RE: RETAINING WALL FOR COTTONWOOD ESTATES SUBDIVISION

REF: GRADING AND DRAINAGE PLAN FOR COTTON WOOD ESTATES SUBDIVISION
(H22-D38) RECEIVED APRIL 17, 1984

REF: Grading and Drainage Plan for COTTONWOOD ESTATES SUBDIVISION
(H22-D38)

DRAINAGE PLAN & REPORT

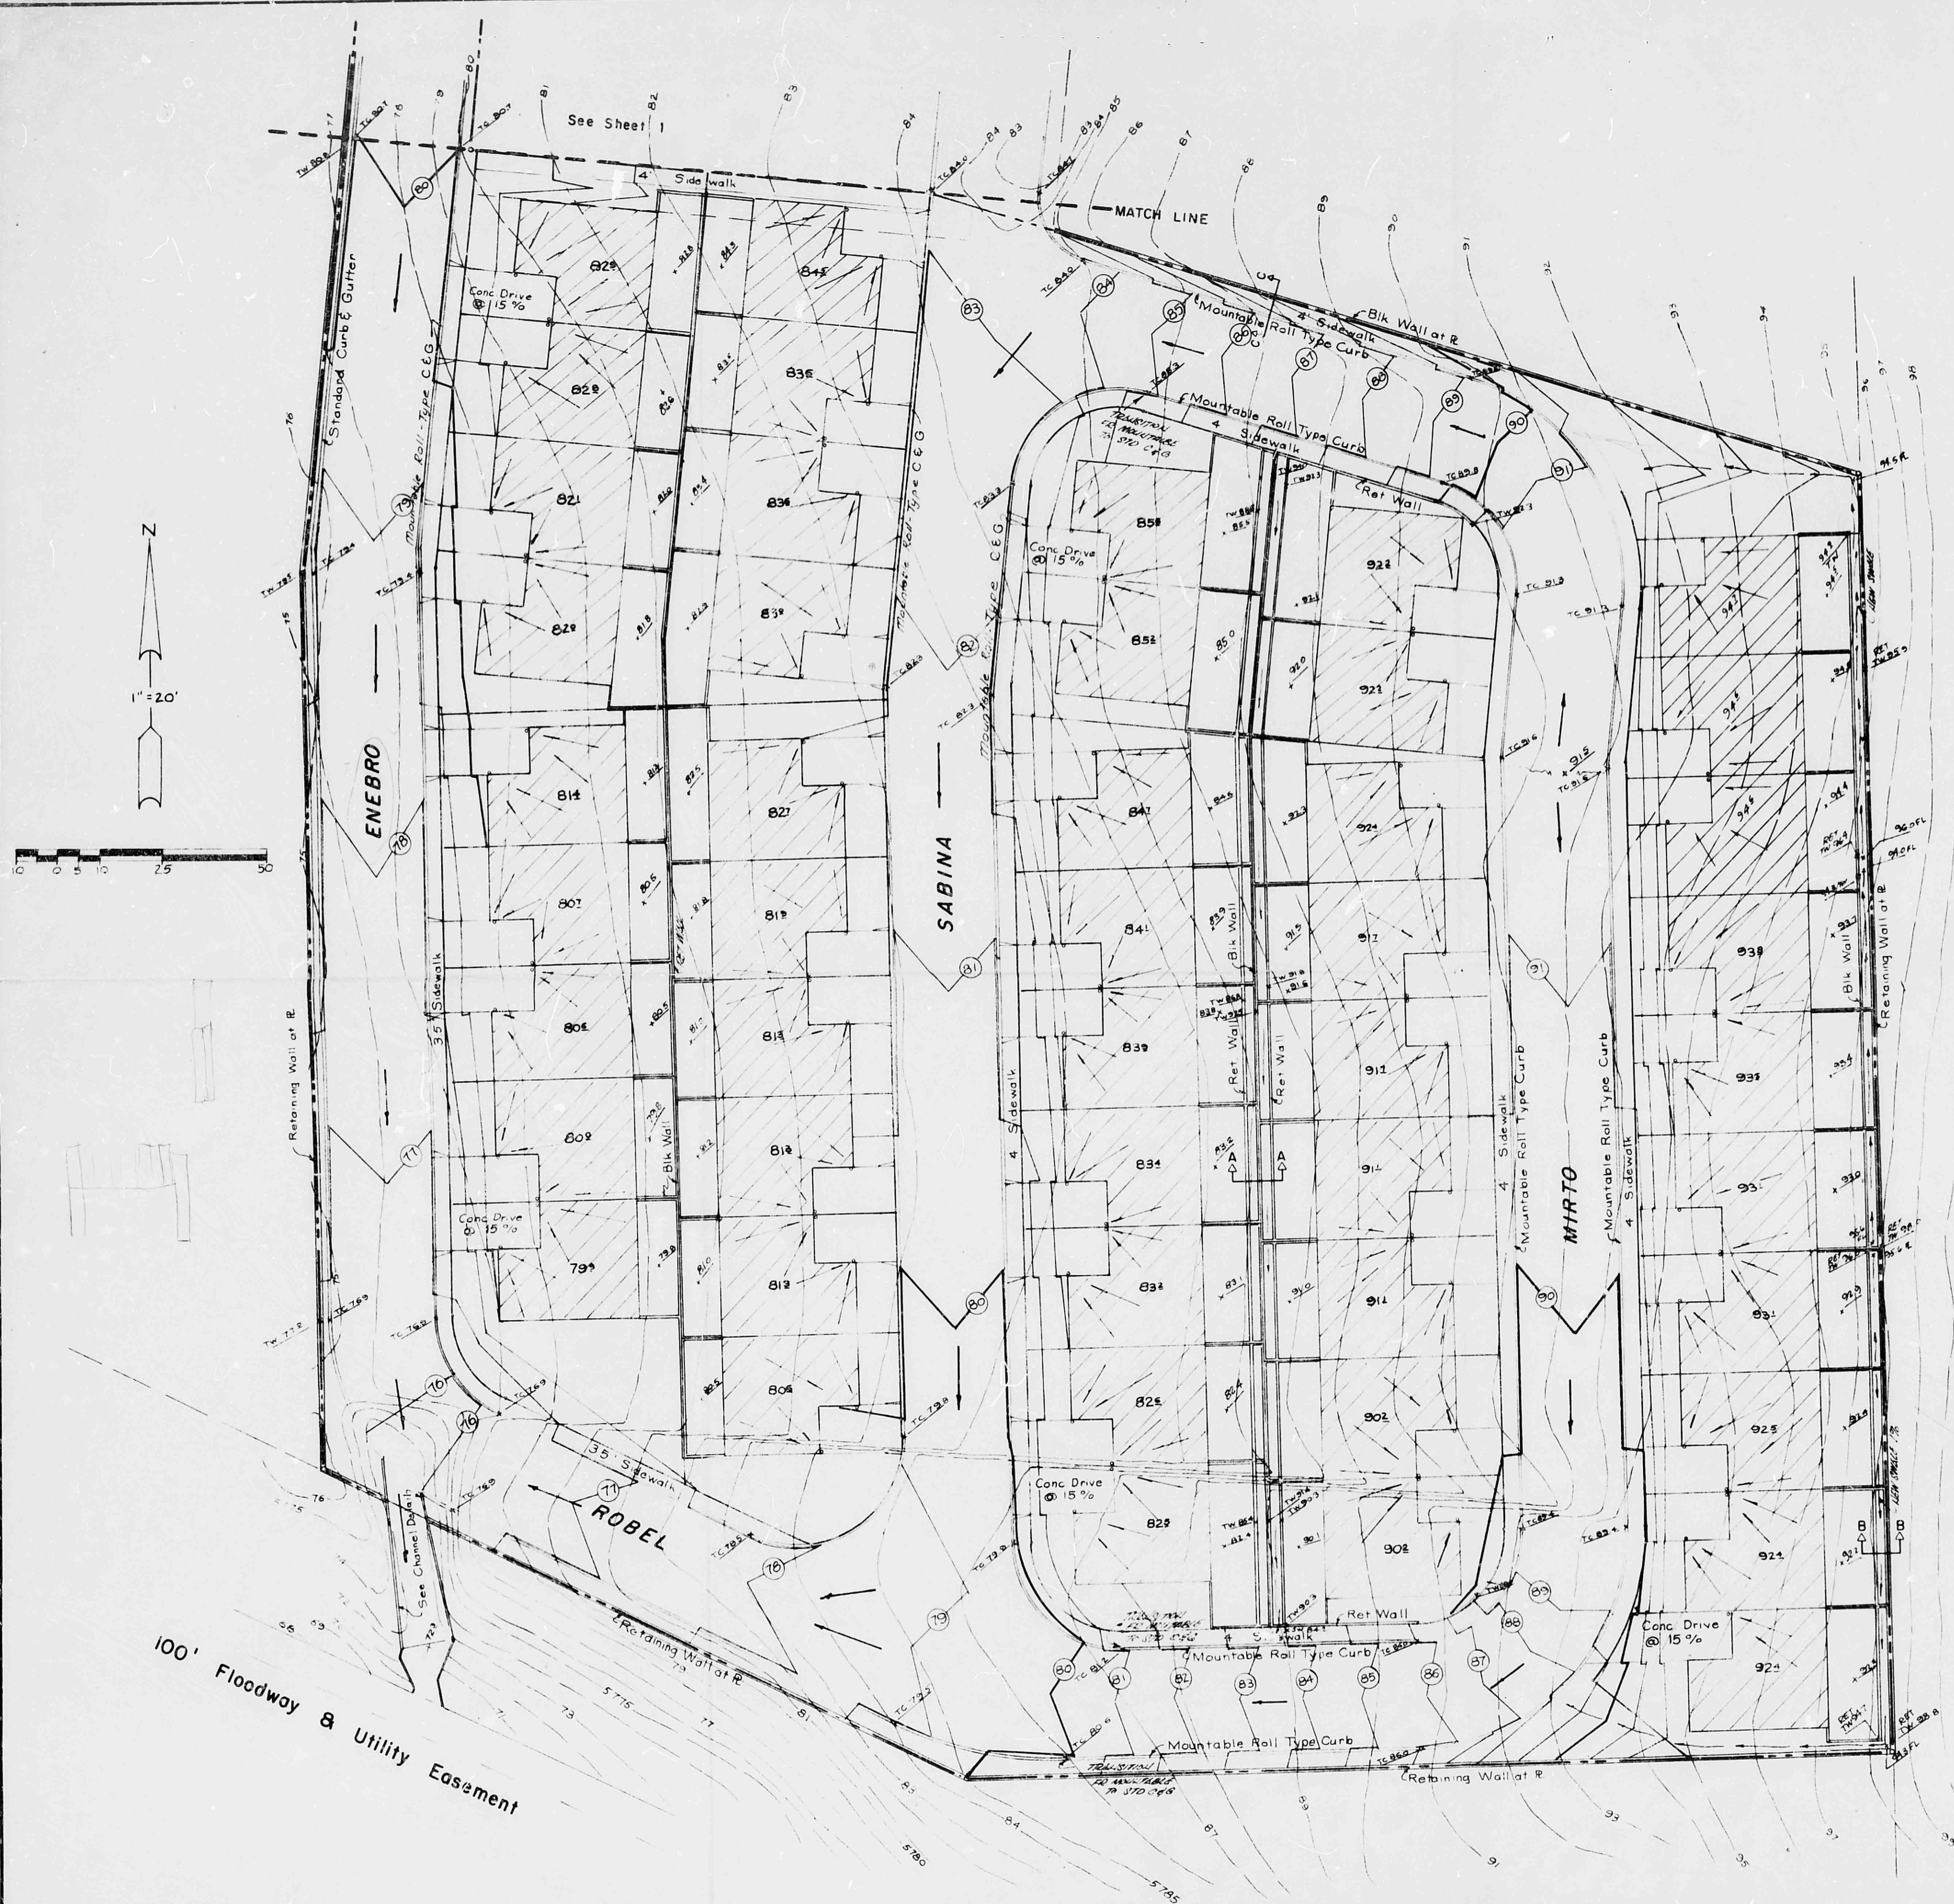
1. The site plan for this development has totally changed from the previous conceptual submittal; therefore, the Conceptual Drainage Approval is null and void. The detail associated with this submittal is only good to grant conceptual approval for this revised layout. It is not of sufficient detail for building permit.
2. Will the water, sewer and paving plans be submitted separately for approval from the City to issue work orders? How is the development of this site to be processed?
3. How are the backyards of each of the lots to drain i.e., there are three (3) walls internal, how are the areas between to drain? Backyard ponding is not allowed as credit for runoff control.
4. The Figure 1 mentioned in the report has been deleted from the submittal.
5. How is it proposed for vehicles to get into the drivepads without any curb-cuts provided?

6. Roof drainage should be indicated.
7. Does the off-site flows just run over the top of the walls? There aren't any elevations shown for the wall on the north end. How do the off-site flows enter?
8. The street names are not the same as shown on the previous submittal. Please provide a copy of the approved plat.
9. For building permit approval the grading plan should be of sufficient detail to build by since it is to be included in the construction set for sign-off.
10. All City standards should be identified and referenced by number of standard.

1. Detail has been added to the site plan as requested. The specific items of detail will be discussed in the comments below. Grading was previously shown only on the streets. It has been extended to remaining non-building areas.

4. Figure one has been included in this submittal.
5. Where mountable curb is called out on the plan, no special treatment of the curb is necessary. Where standard curb is called out, curb cuts have been shown on the plan.

6. Roof drains have been added to all buildings.
7. Sections BB and CC show that off-site flows will enter the property through holes in the block wall formed by turning an occasional block sideways. Once inside the wall it will flow in the direction indicated by arrows on the plan.

DETAIL OF 8" CMU RETAINING WALL
Not To Scale - K-11-Z

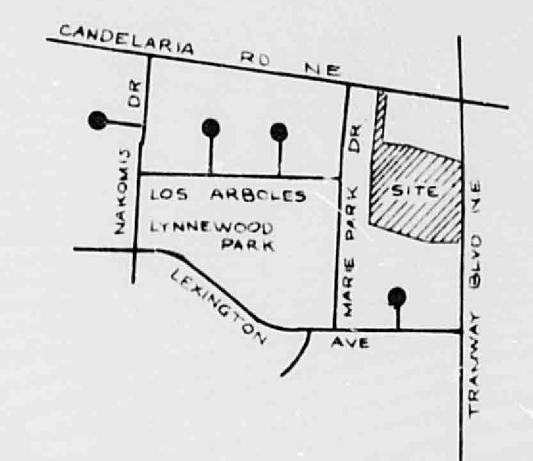
The approved drainage plan for the Cottonwood Estates Subdivision indicates a retaining wall would be constructed on the west property line. A recent field trip to the site showed that the existing CMU wall had not been replaced. Please be advised that a retaining wall will be required as shown on the approved drainage plan submitted by Hall Engineering. Please contact Code Administration for the retaining wall permit.
